Your Reference: SSD 8790
Our Reference: NCA/2/2018
Contact: Maya Sarwary
Telephone: 9806 5578

SSD 8790 - Redevelopment of Parramatta West Public School

City of Parramatta Submission

Appendix 1C: Tree Protection Plan - Parramatta West Public School

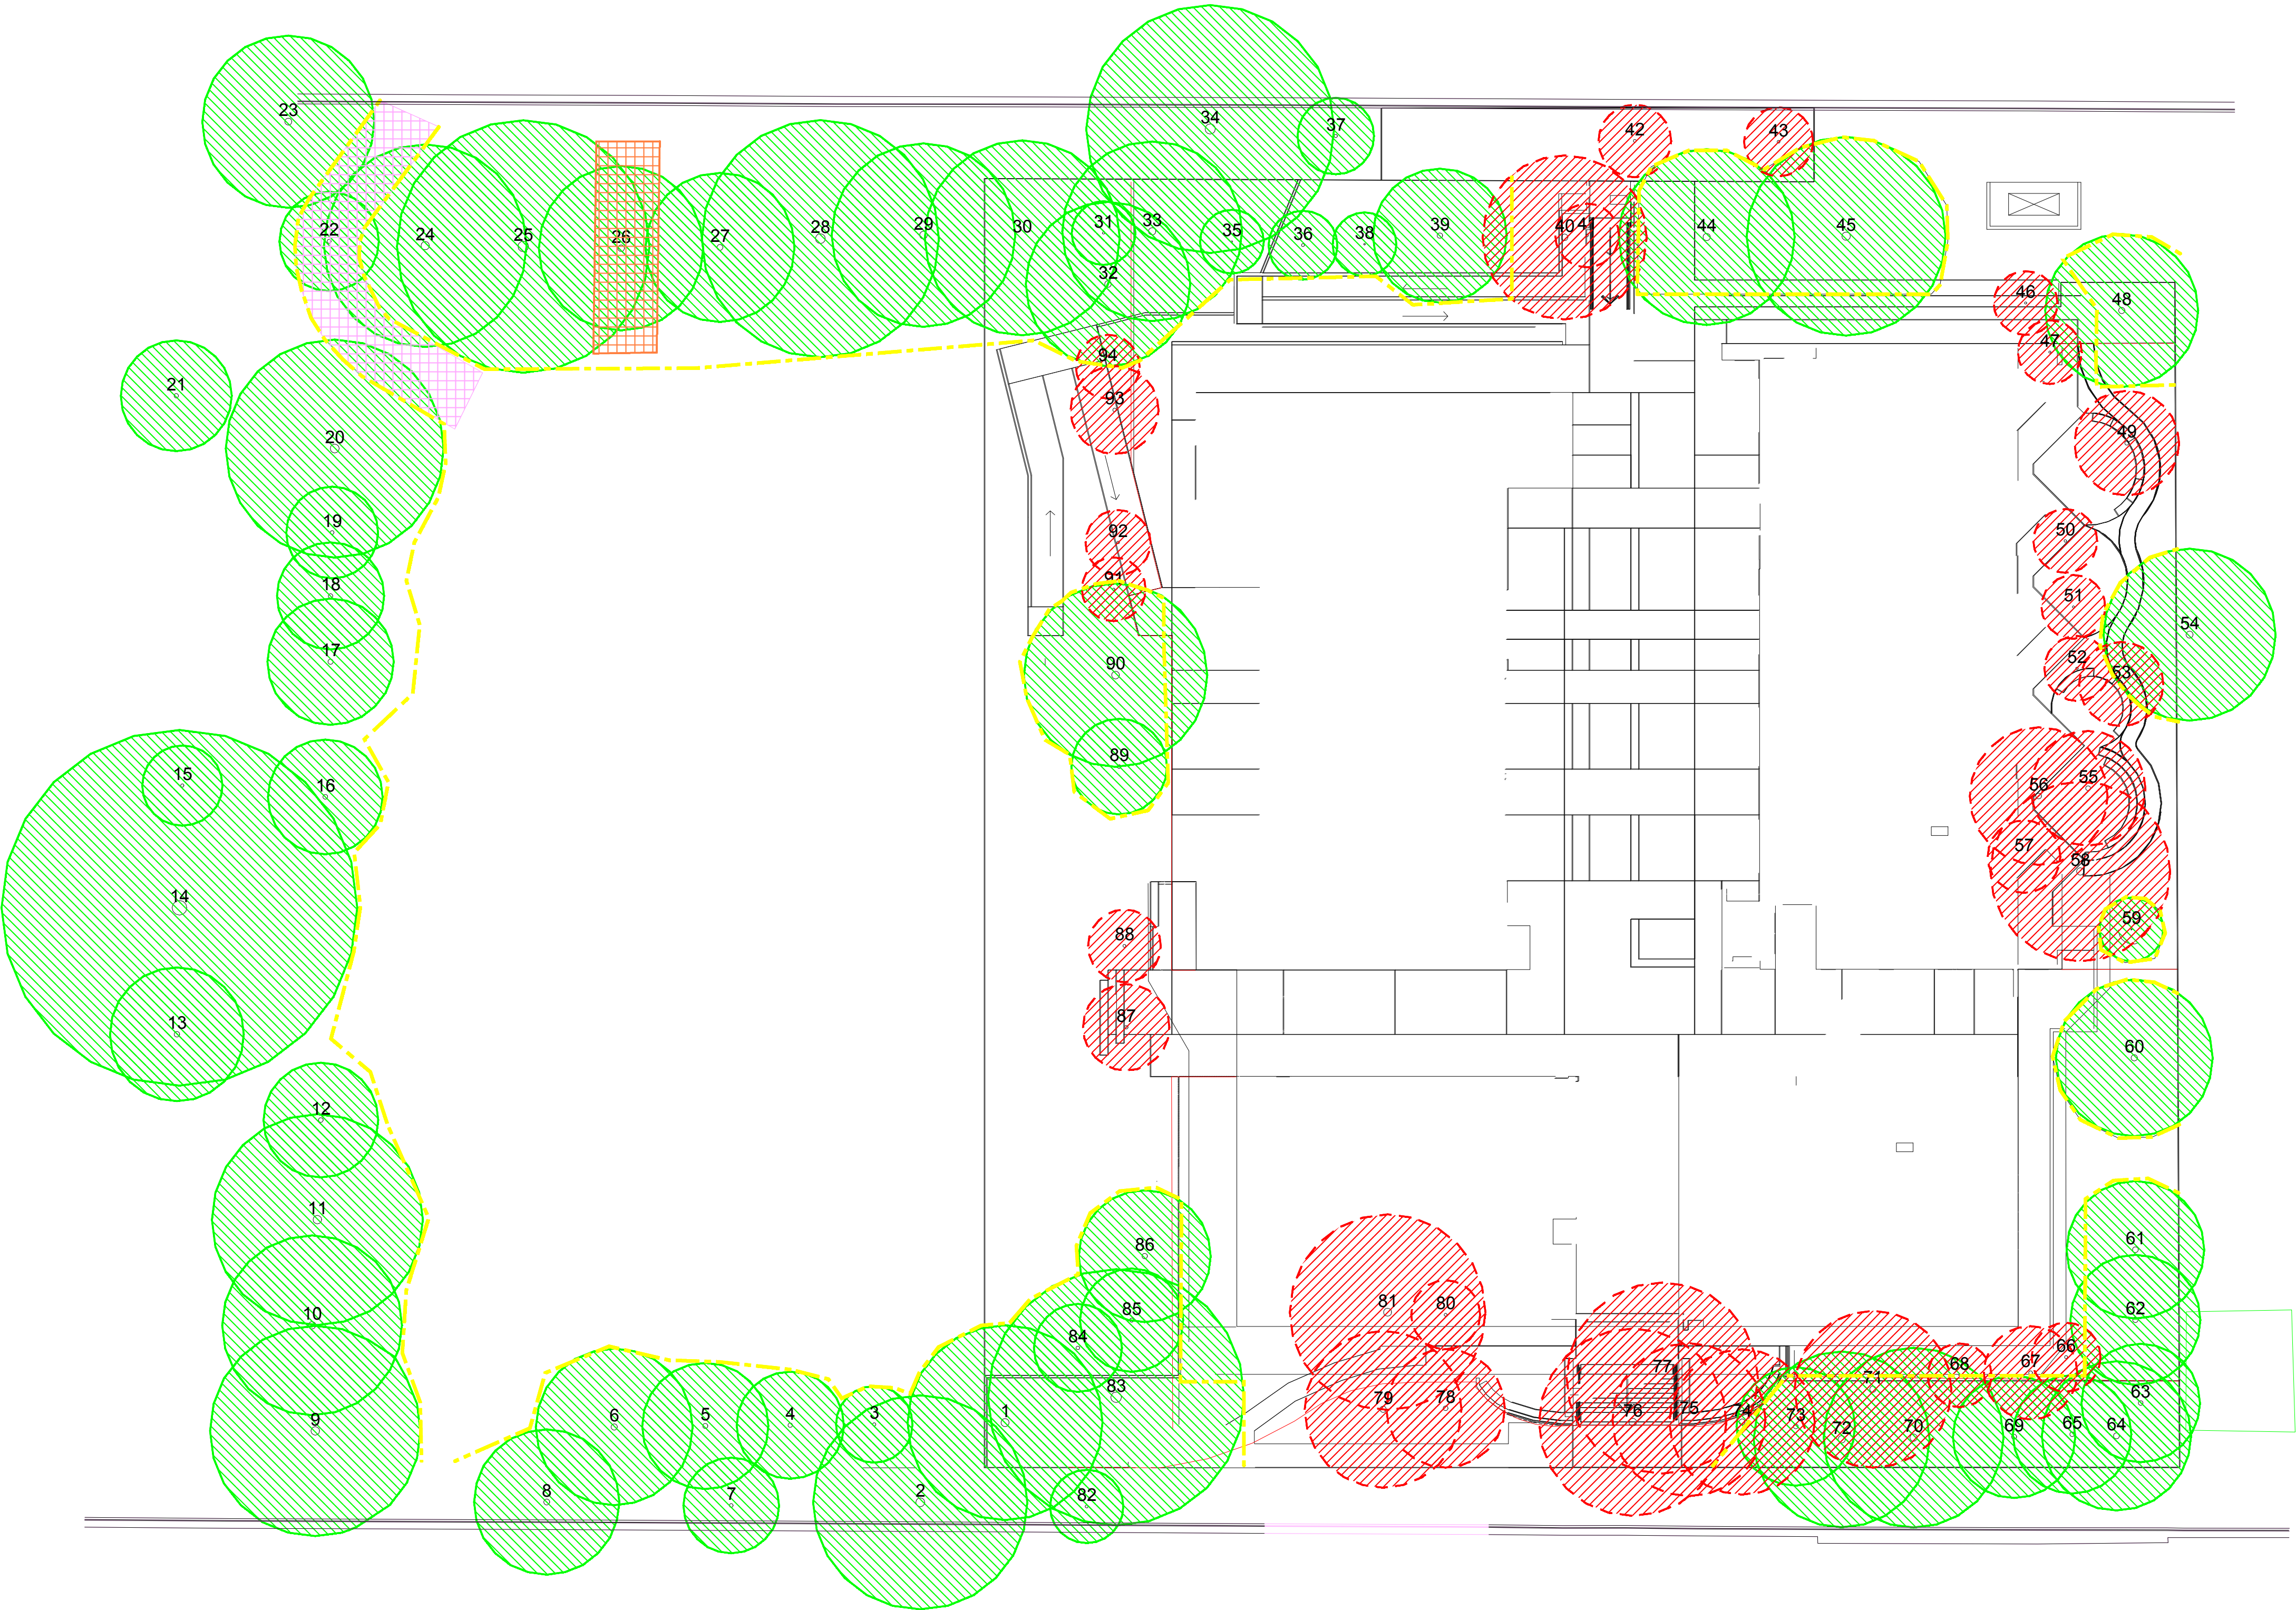
There are a number of mature existing trees located on the subject property which will either incur impacts or require removal in order to facilitate the proposal. The following recommendations are made: -

- Existing mature trees, assessed by a AQF Level 5 Arborist, should be retained where possible. Consideration should be made for the retention of existing mature trees and vegetation to the perimeter boundaries of the site with additional supplementary planting to provide screening and scale to the built form whilst strengthening locally endemic plant communities.
- A recommendation is made to engage a AQF Level 5 Consulting Arborist to provide advice as to suitable locations and planting distances for large trees to minimise risk to high pedestrian zones and impacts to infrastructure.

- The engagement of a AQF Level 5 Arborist ('Project Arborist') to provide an Existing Tree Management Plan to incorporate tree protection measures in accordance with AS4970-2009 (Protection of Trees on Development Sites).
- The Project Arborist must supervise all constructions works, including demolition and site management, within five (5) metres of any existing tree to be retained.
